***Lot 1 DP 702144 & Lot 100 DP 624581  
86-96 and 100 Mount Street, North Sydney***

***MP 08\_0241 MOD 2 – Modification to the approved  
Commercial and Retail Development***

Secretary's Environmental Assessment Report  
Section 75W of the *Environmental Planning and  
Assessment Act 1979*

drawing Plan - B3 Level

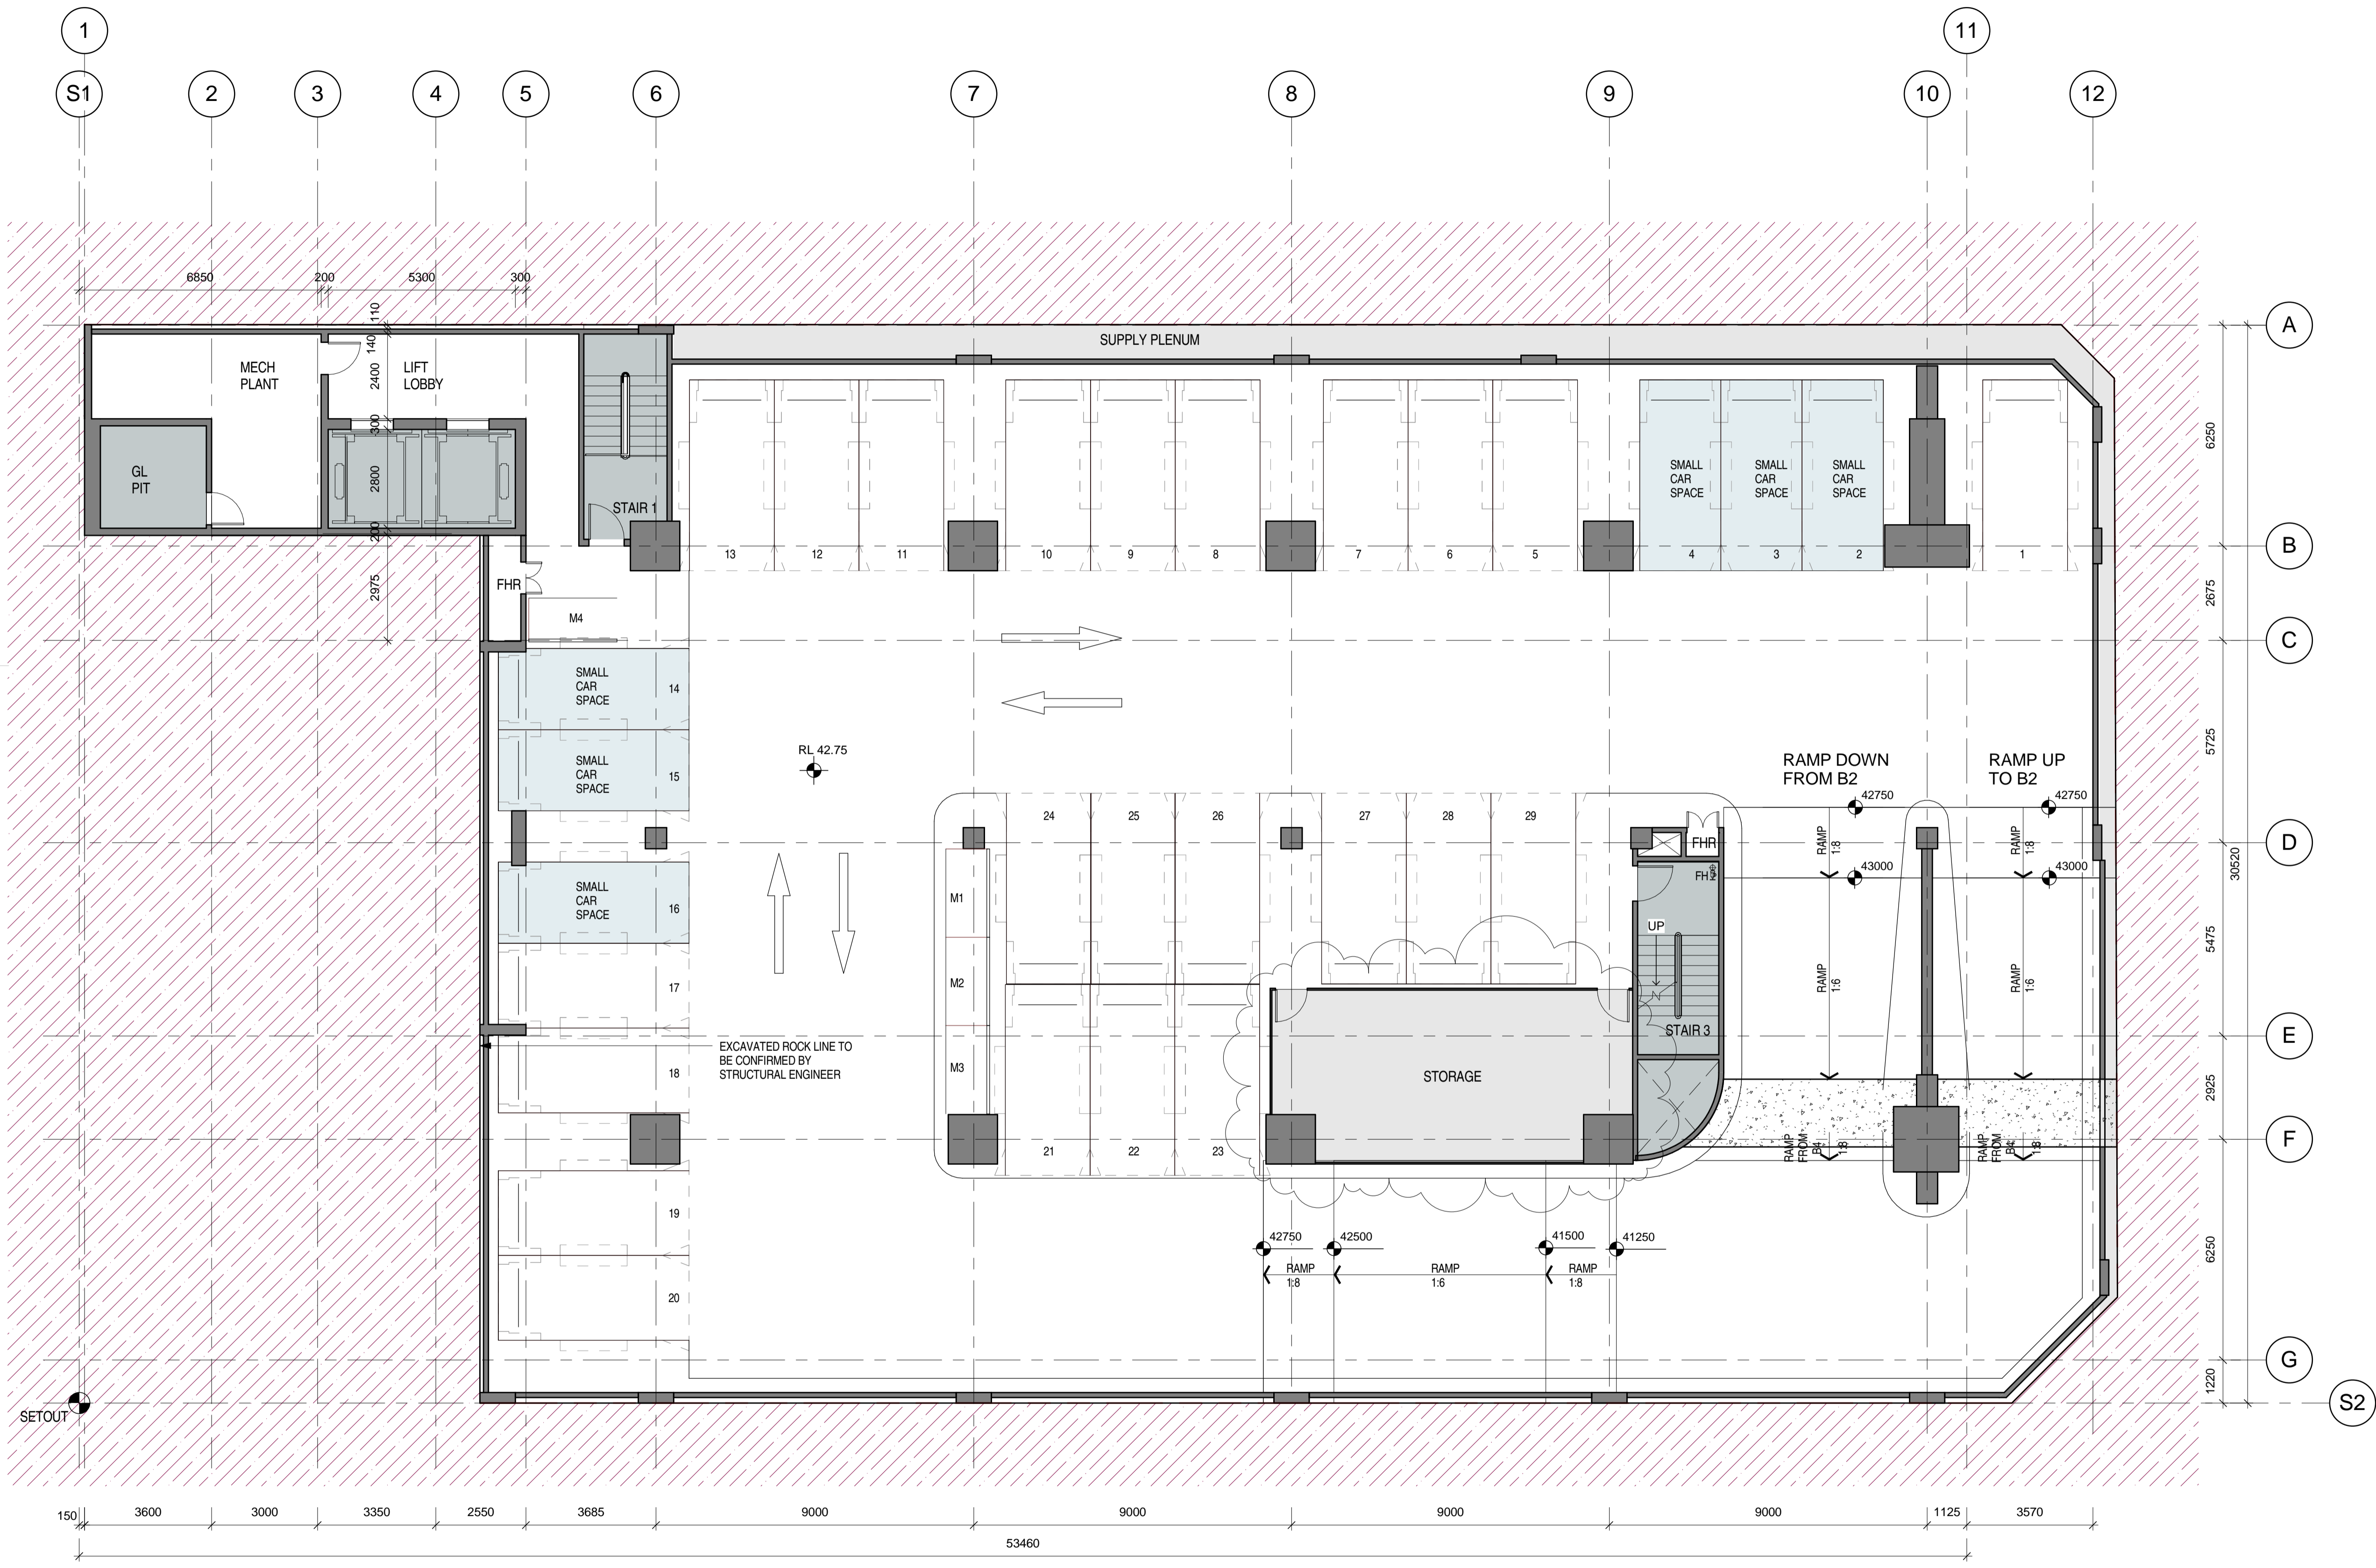
- enlarged basement level B6;
- reduced basement level B3 at the south eastern corner to respond to CBD rail link excavation requirements;
- rearrangement of car parking at various levels whilst providing the approved 113 car spaces over 6 levels;
- consolidation and relocation of all bicycle parking to basement level B2; and

The Department notes that the reconfigured basement layout will not result in any material changes to the overall approved intent and use of the basement levels. The consolidation of bicycle car parking at level B2 will improve its useability for future bicycle users.

drawing
 Ground Floor Plan

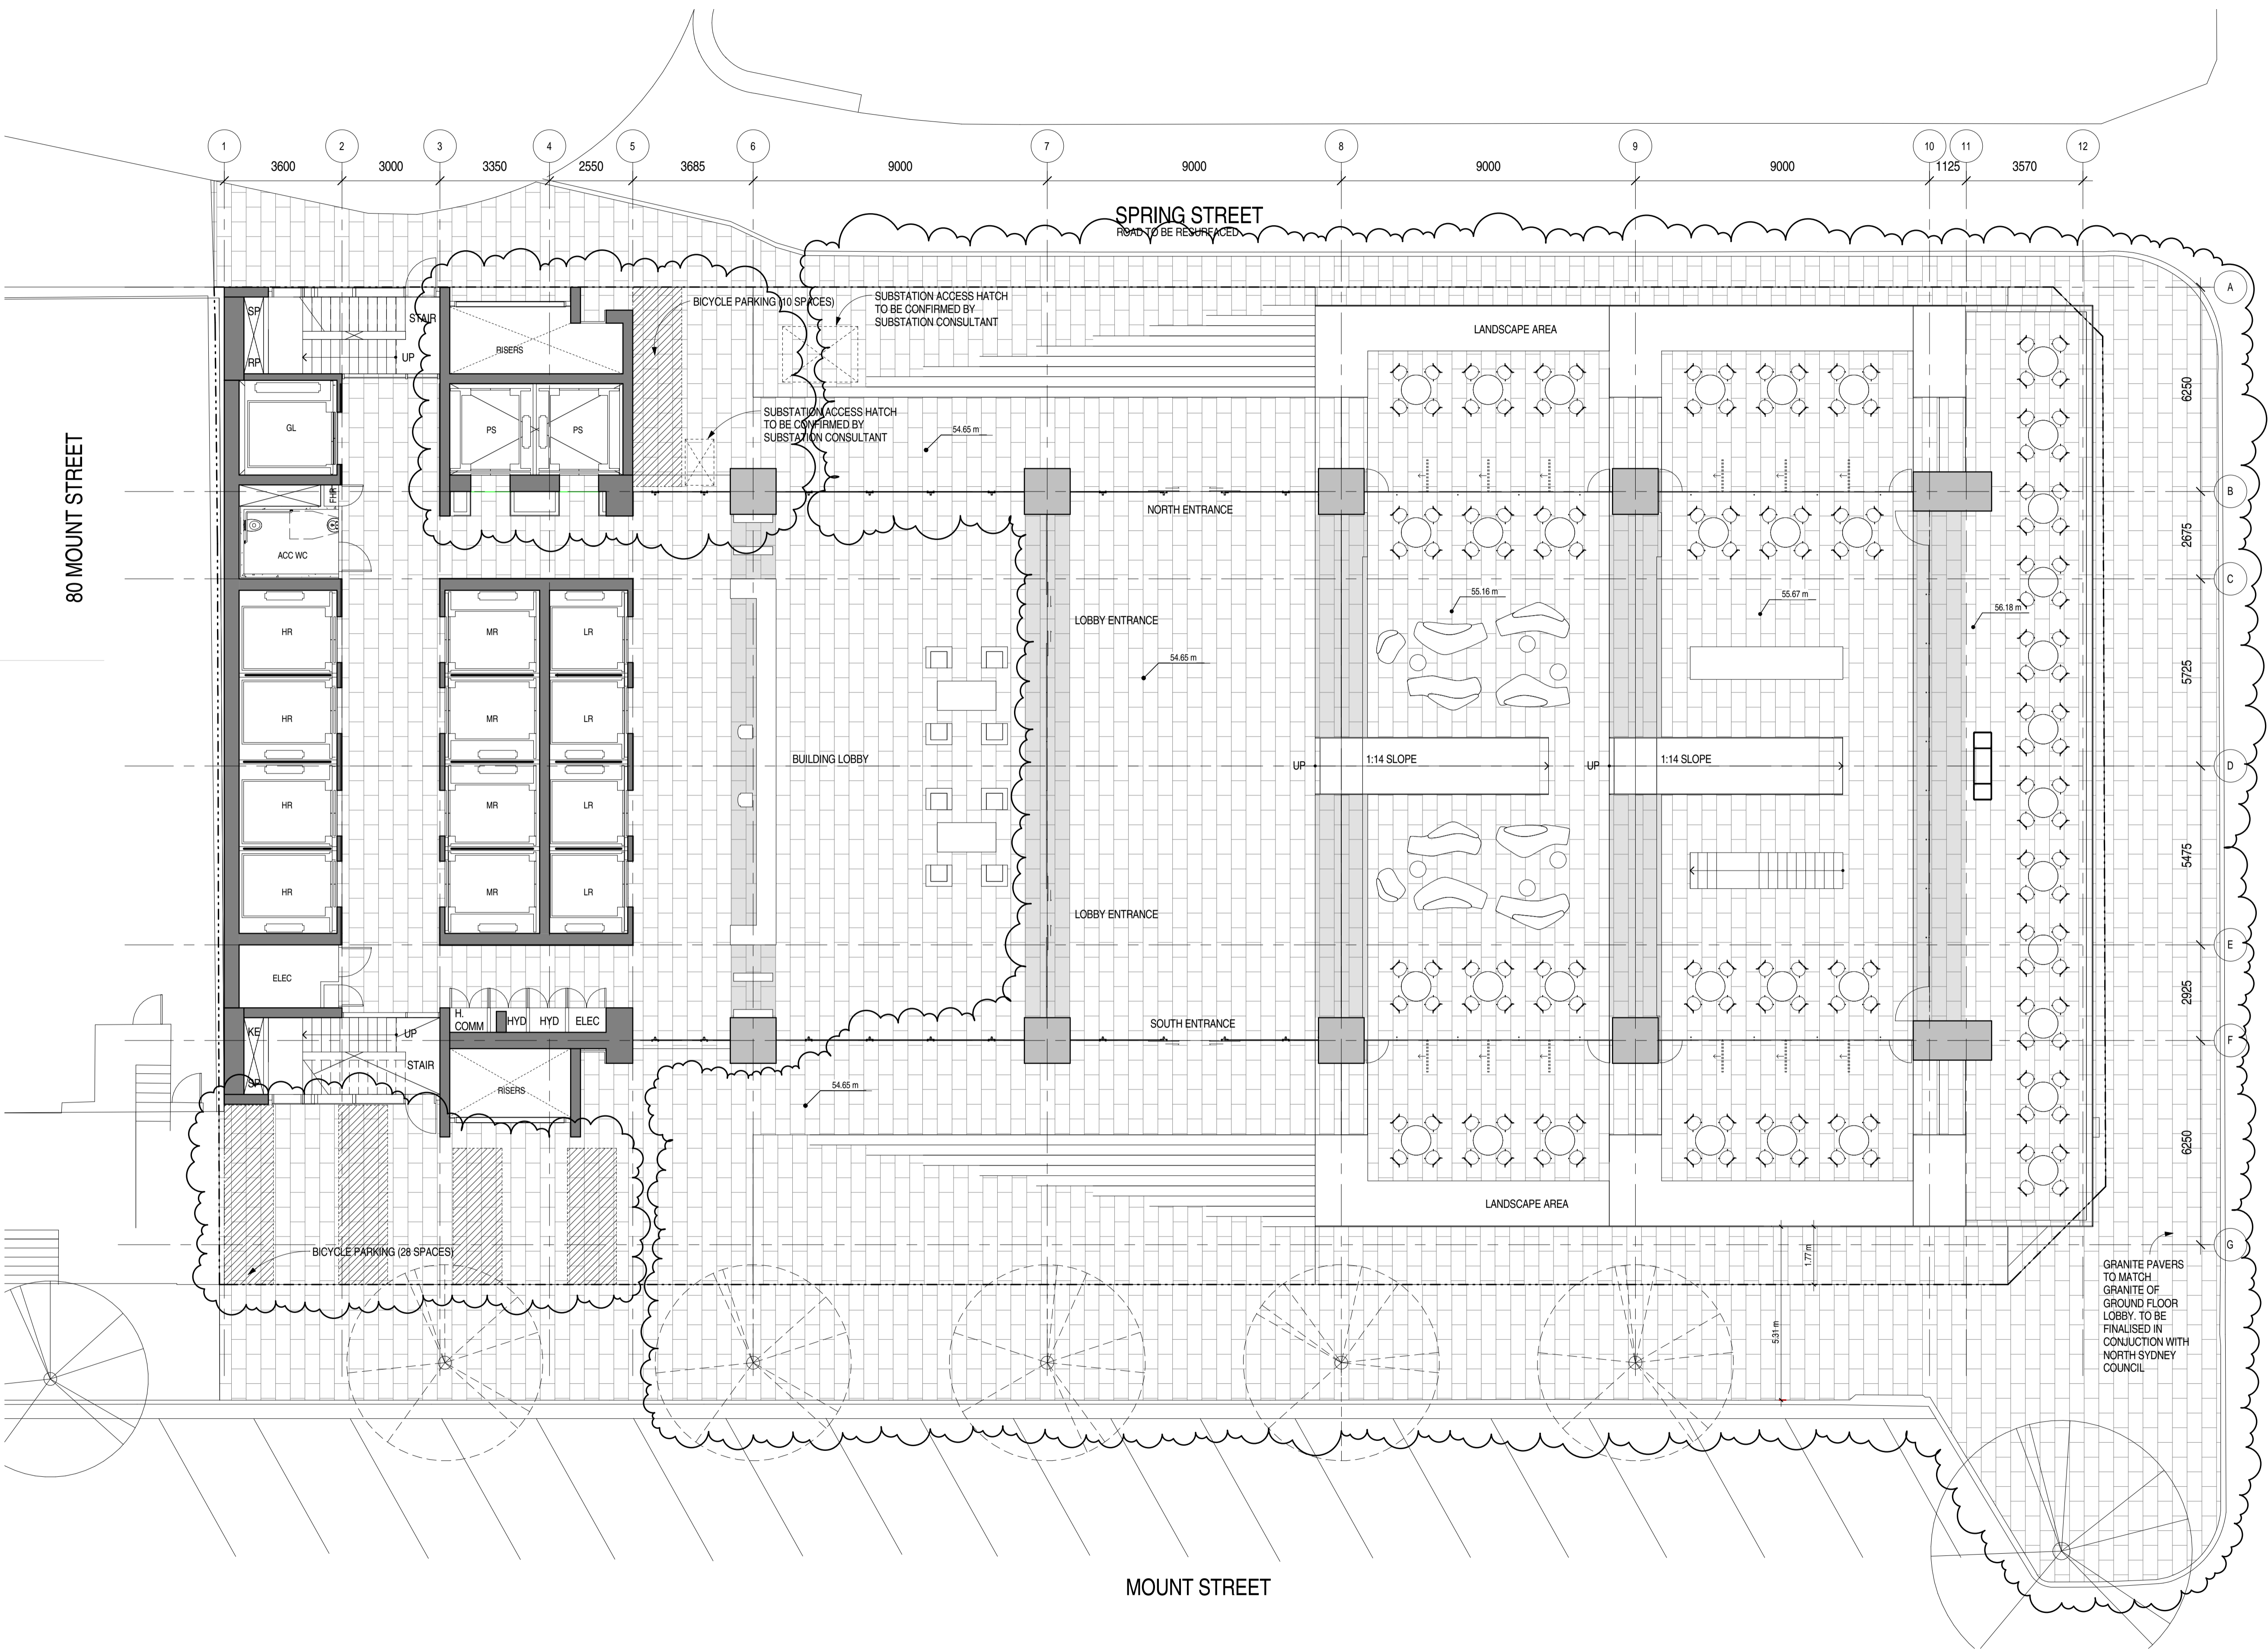
The proposal involves the modifications to the lower ground and ground floor level layout, and various elements of the public domain design and treatment including:

- increase in the size of the retail/café area and outdoor seating area;
- enclosure of the ground floor café and through site link with glazing for weather protection;
- granite pavers for the public domain (Walker, Spring and Mount Street pavements) to be discussed and agreed with Council;
- provision of 28 external bicycle spaces in the south western corner of the site, and 10 spaces in the north western corner of the site;
- reduction of street trees at Walker Street from three to two to make allowance for car park driveway cross over to the site; and
- other minor layout changes (**Figure 7**).

The Department concludes that the proposed changes are acceptable. The modifications to the lower ground floor and ground floor levels will improve the overall useability of the ground floor space and public domain. Further, the increase in the retail/café area will further activate the façade, public domain and through site access. The reduction in trees is appropriate given the original approval for three trees did not consider the requirements for a driveway crossover at Walker Street, approved as part of MOD 1.

Council did not raise any objections to the proposed changes but has requested that a condition of approval be provided requiring that the proposed bike parking and final public domain design comply with Council's Public Domain Style Manual (and other relevant standards) and be approved by Council. The Department has recommended an appropriate condition of approval.
